From: Sarah Jolley [REDACTED]
Sent: 24 May 2022 10:11
To: Planning.Responses <Planning.Responses@arun.gov.uk>
Subject: RE: Planning Consultation on: BN/48/22/PL

Application No: BN/48/22/PL
Registered: 27th April 2022
Site Address: Stoneyfield Cottages Eastergate Lane Eastergate PO20 3SL
Grid Reference: 495466 106023
Description of Works: Variation of condition imposed under BN/112/21/PL relating to condition 2-plans condition.

FOR MR & MRS MITCHELL		
SITE SITE AT: STONEFIELD NURSERY, EASTERGATE LANE, EASTERGATE. PO20 3SL		
TITLE SITE PLAN SHOWING PROPOSED DWELLING		
SCALE 1:100 © A2	DATE 03/22	DRAWING NO. 01P REV C

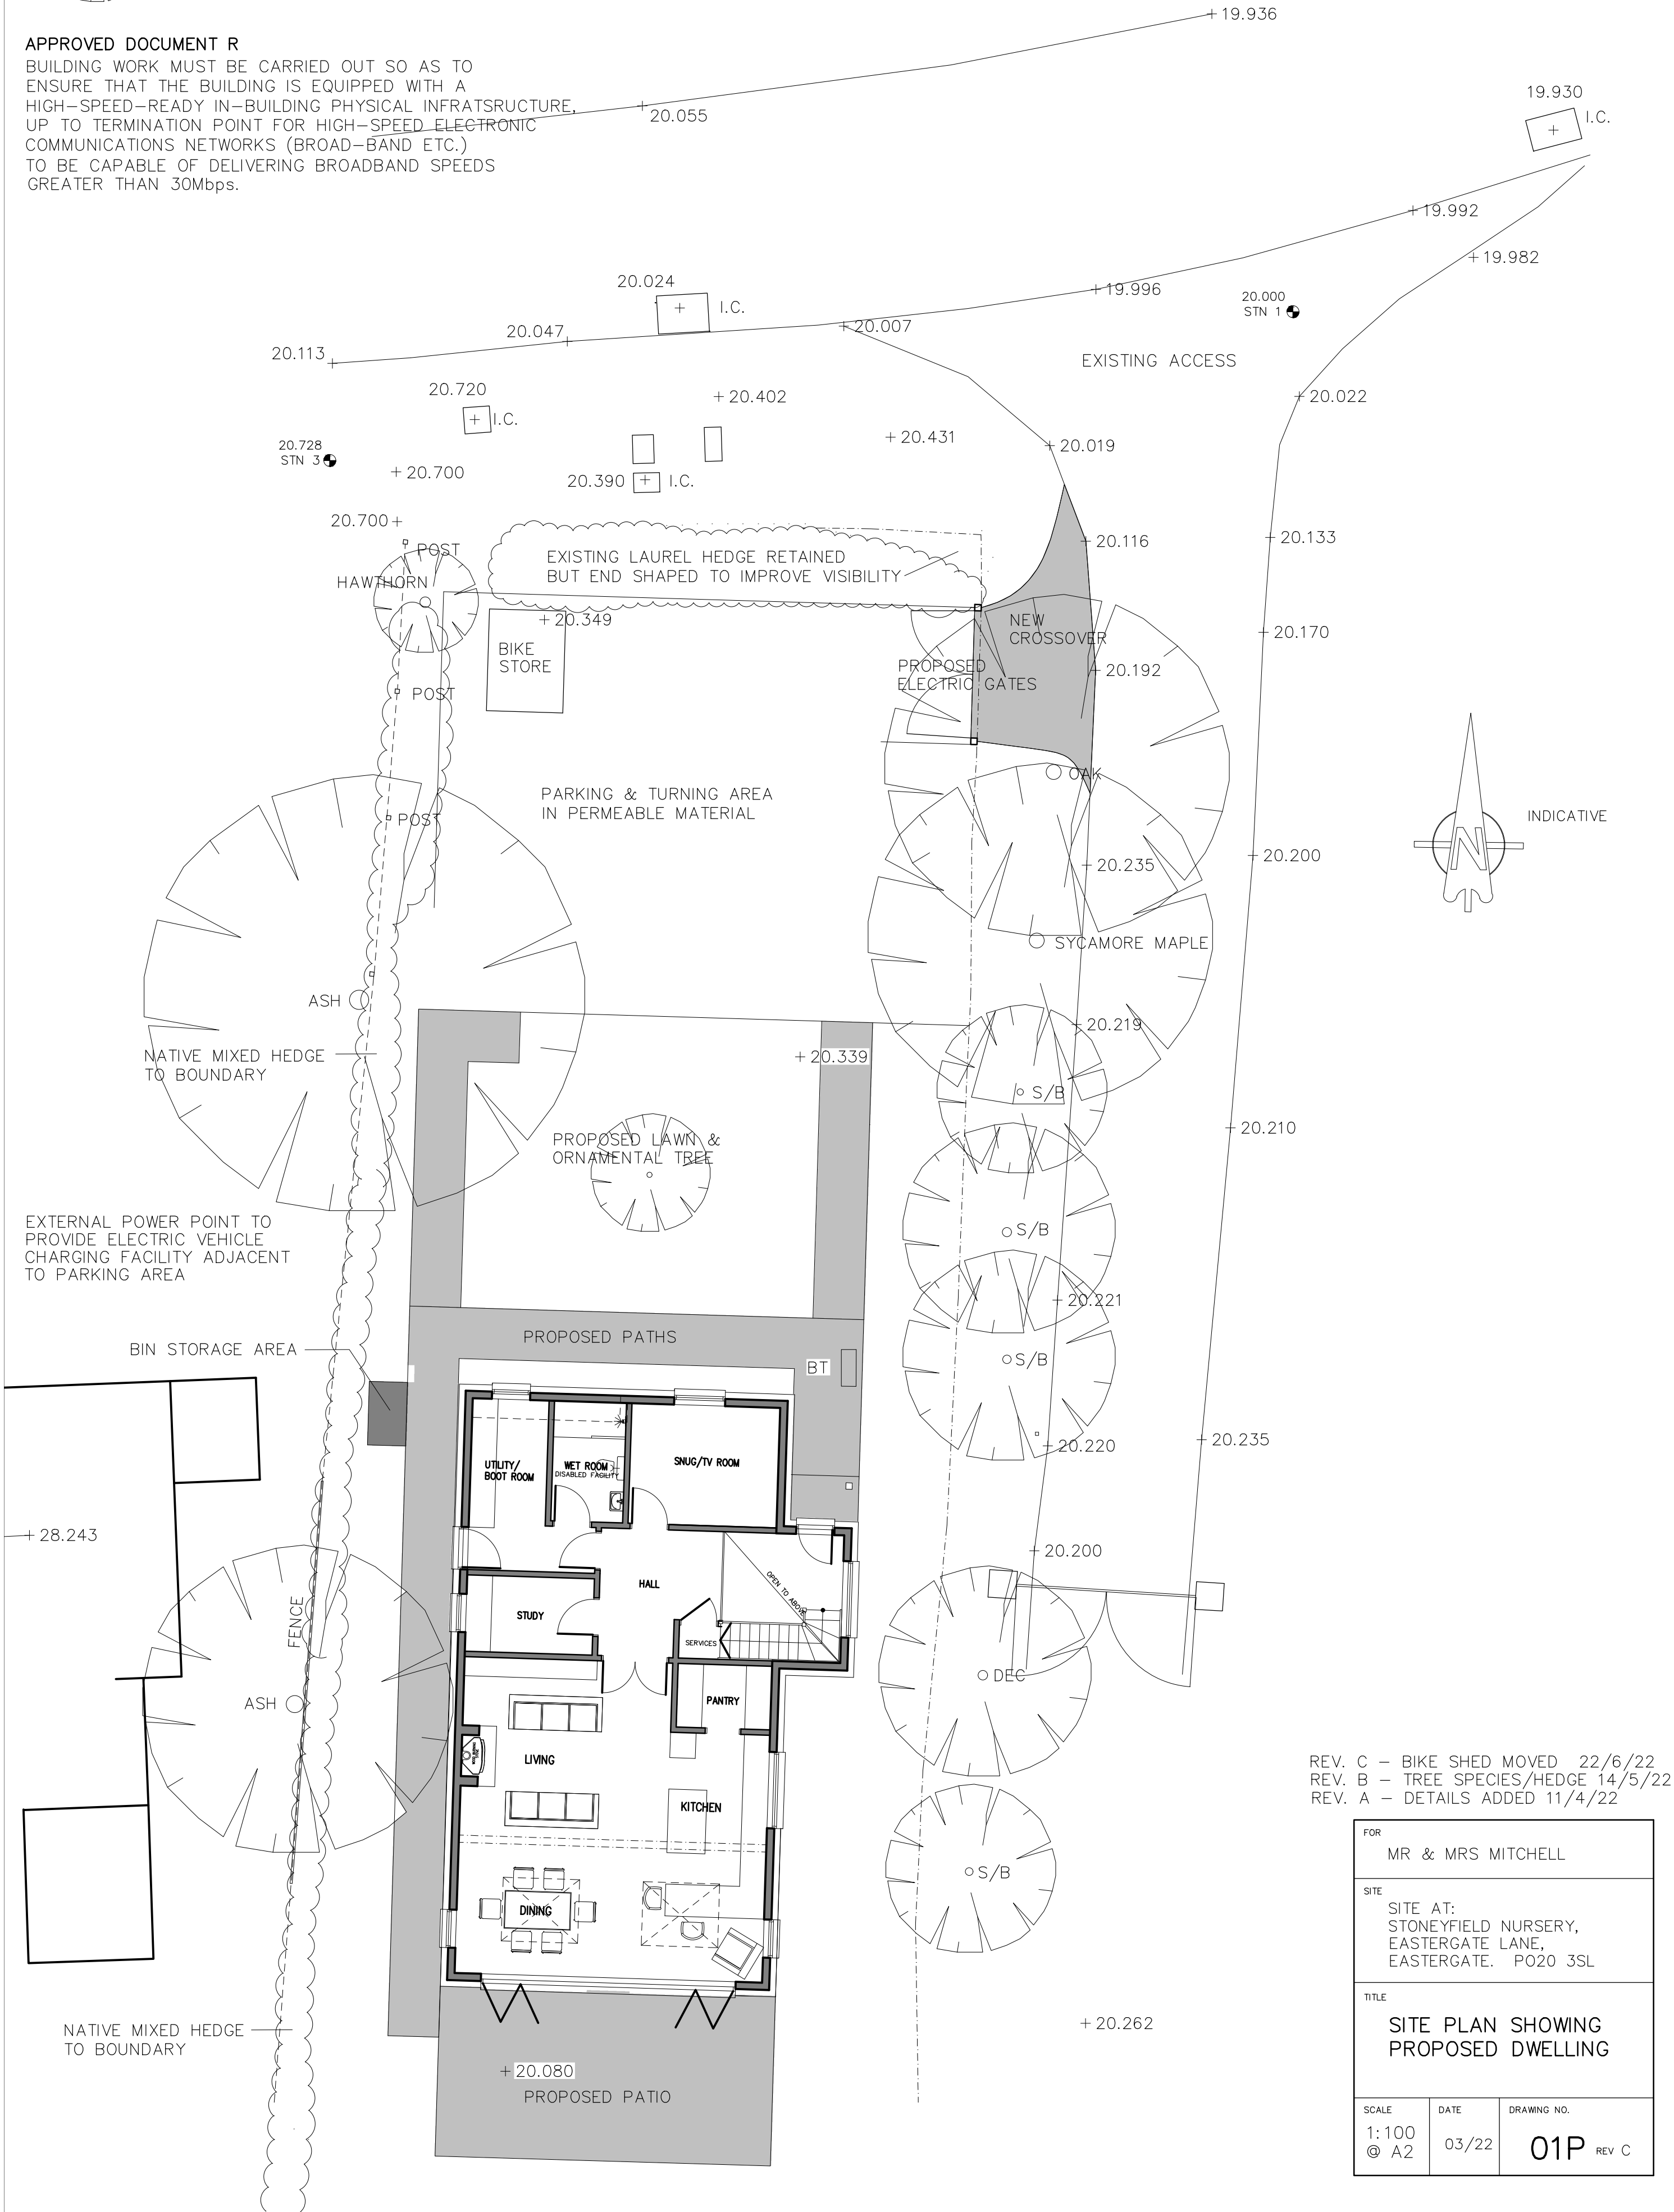
As the Planning and Environment Committee of Barnham and Eastergate Parish Council does not meet until after the deadline for response this application has been considered via an email exchange with the Committee Members and they agreed to submit an objection to this application. The Committee noted that the application appears to impact on the tree root protection zone of the Chestnut tree, and in addition the Juliet balcony is not in keeping with the area.
